# WILLOW SPRINGS RANCH FILING NO. 2

STREET  
PLAN COVER

**MOUNTAIN MUHLY DRIVE**  
**PLAN & PROFILE**

# CD\_V1 redline.pdf Markup Summary

PEDESTRIAN RAMP DETAIL
FOR DETECTABLE PAVERS

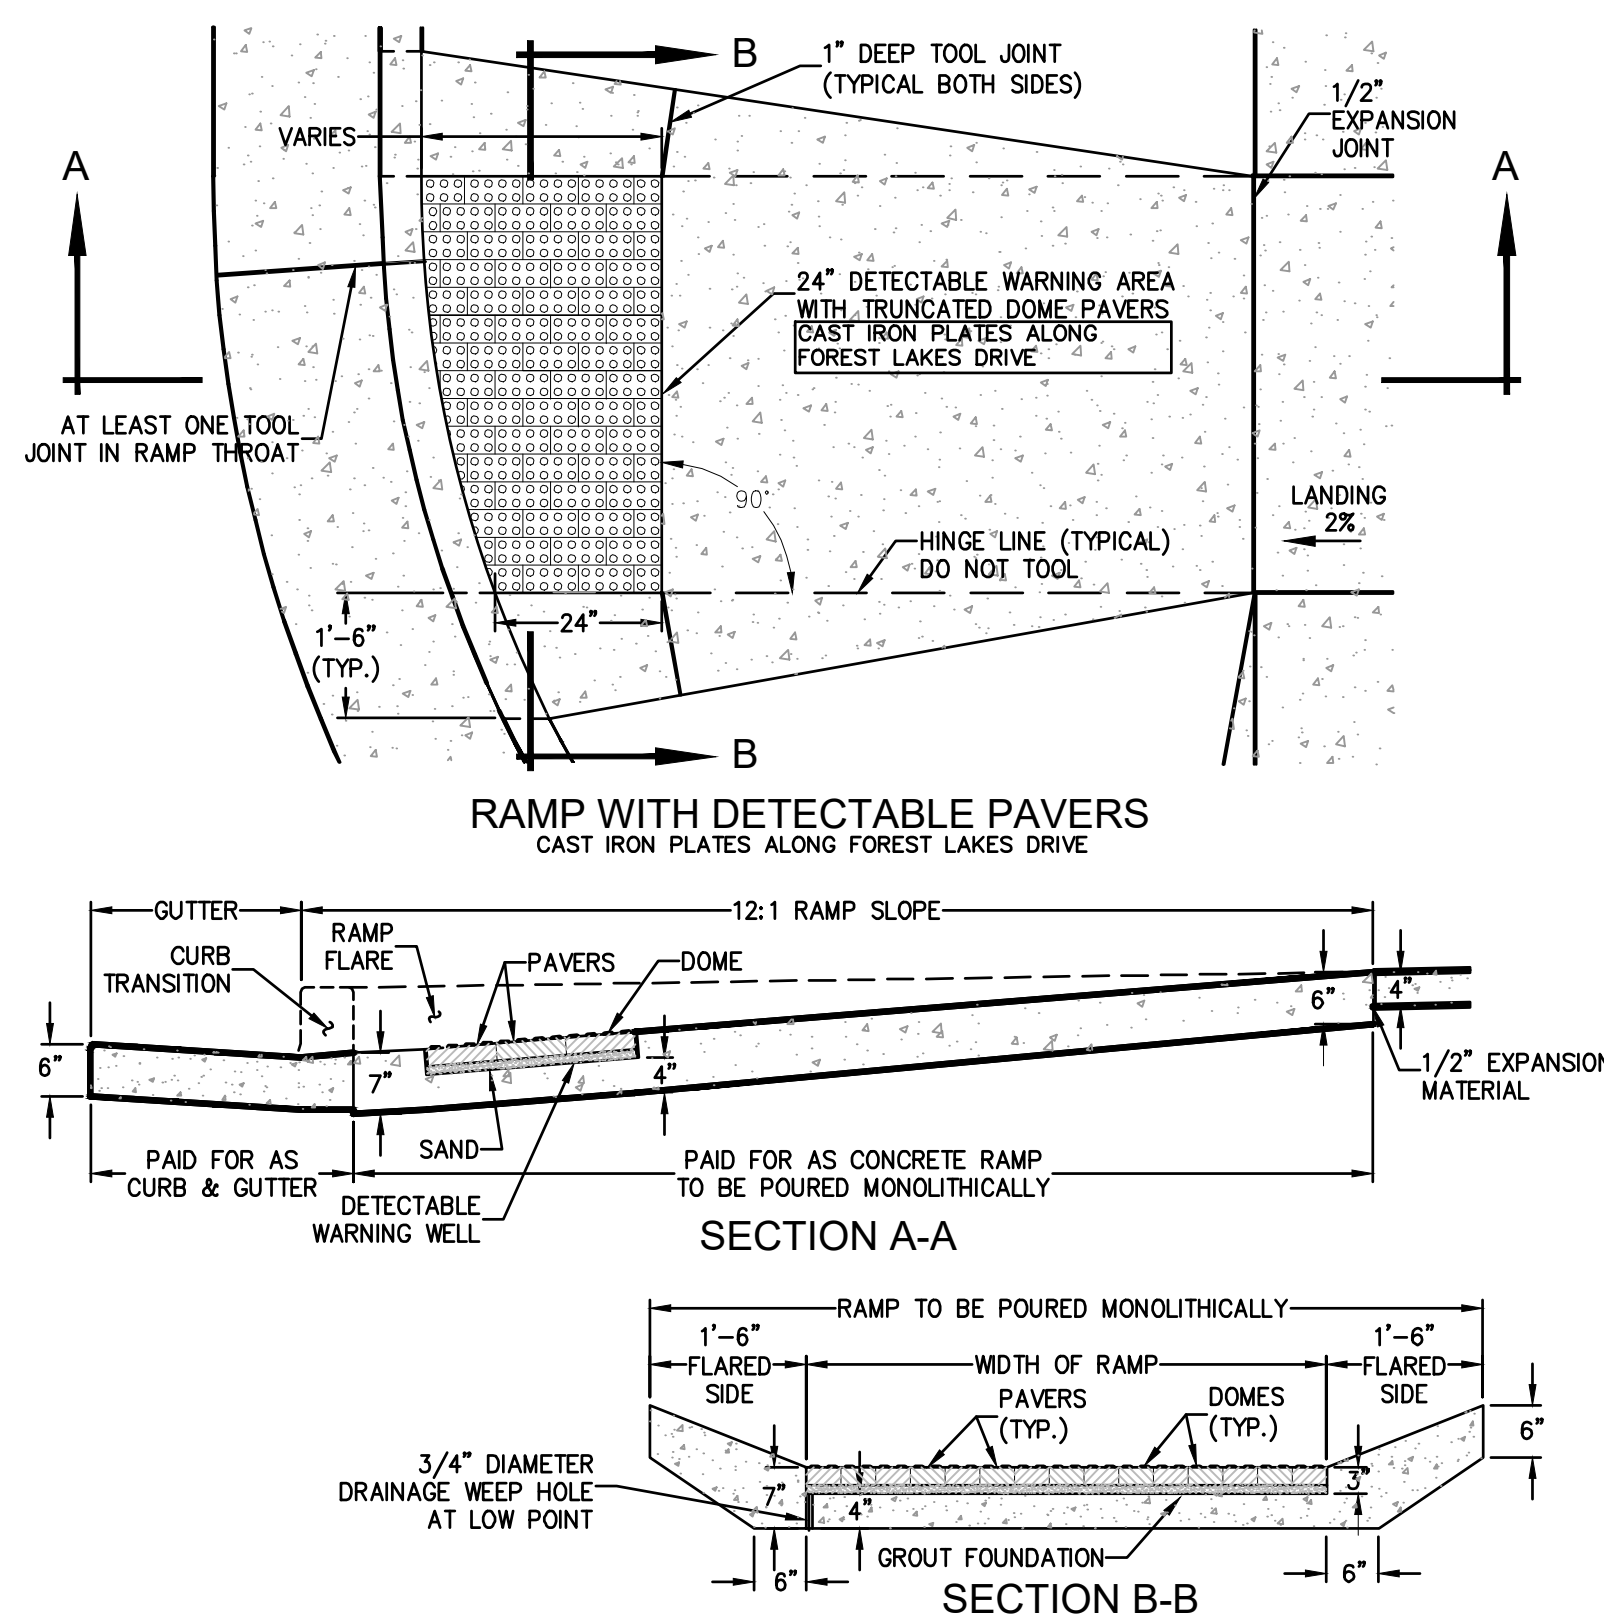
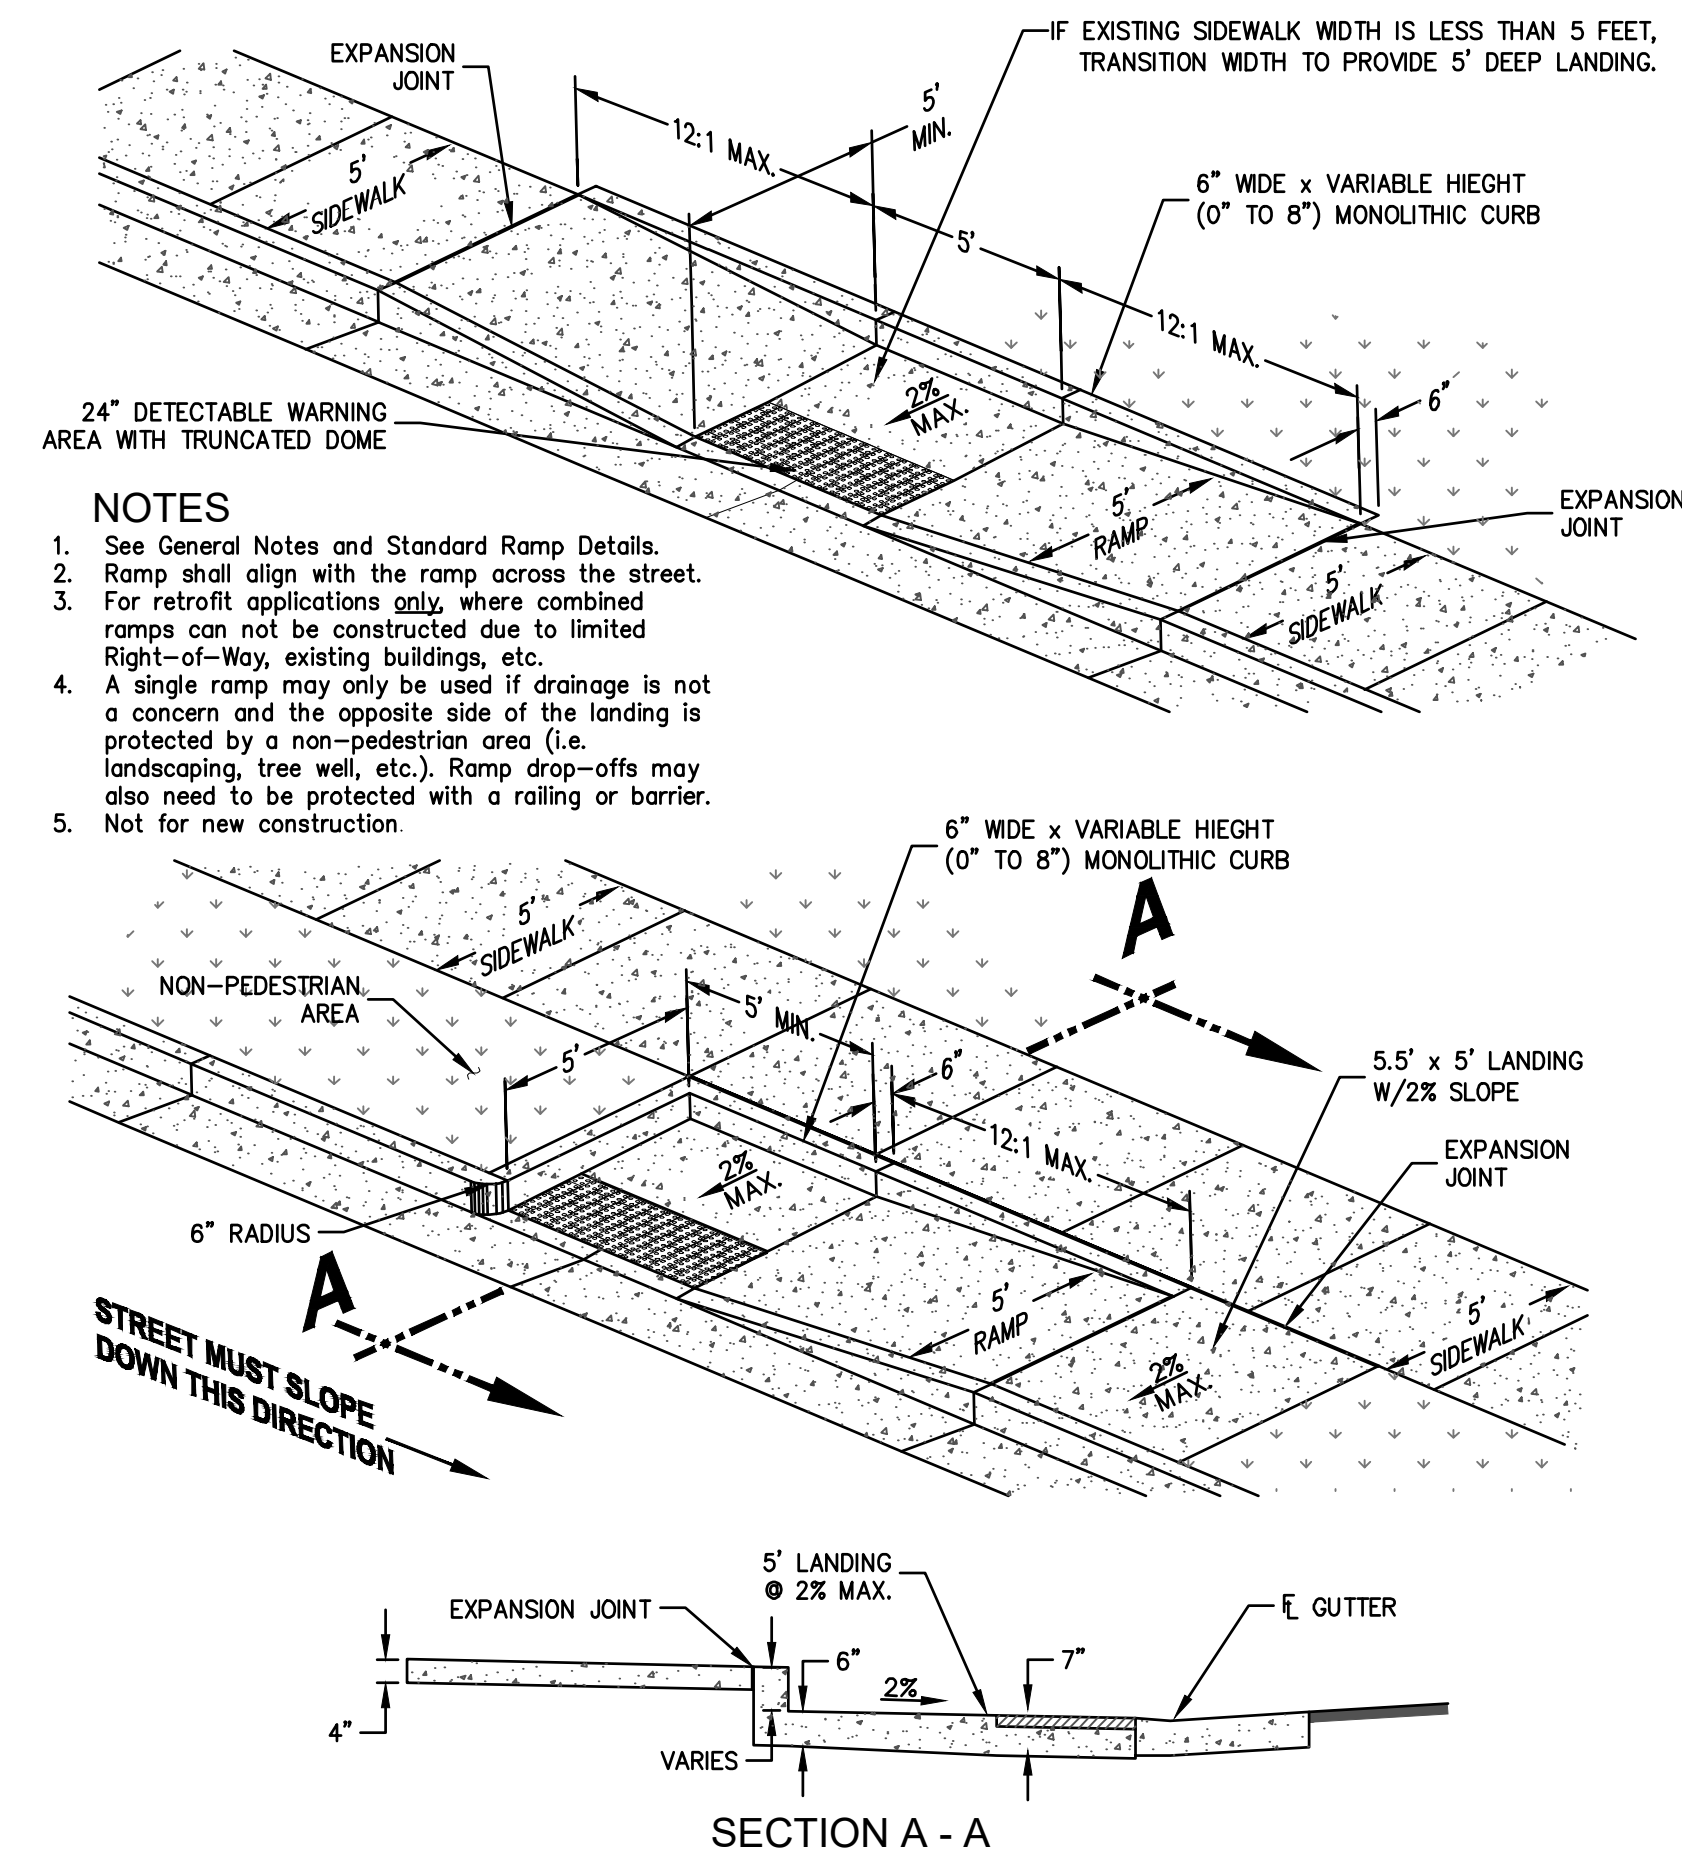
Insert the following county details:  
- SD\_2-40 Pedestrian Curb Ramp Detail  
- SD\_2-41 Pedestrian Curb Ramp Detail  
- SD\_2-42 Detectable Warning Surface Details
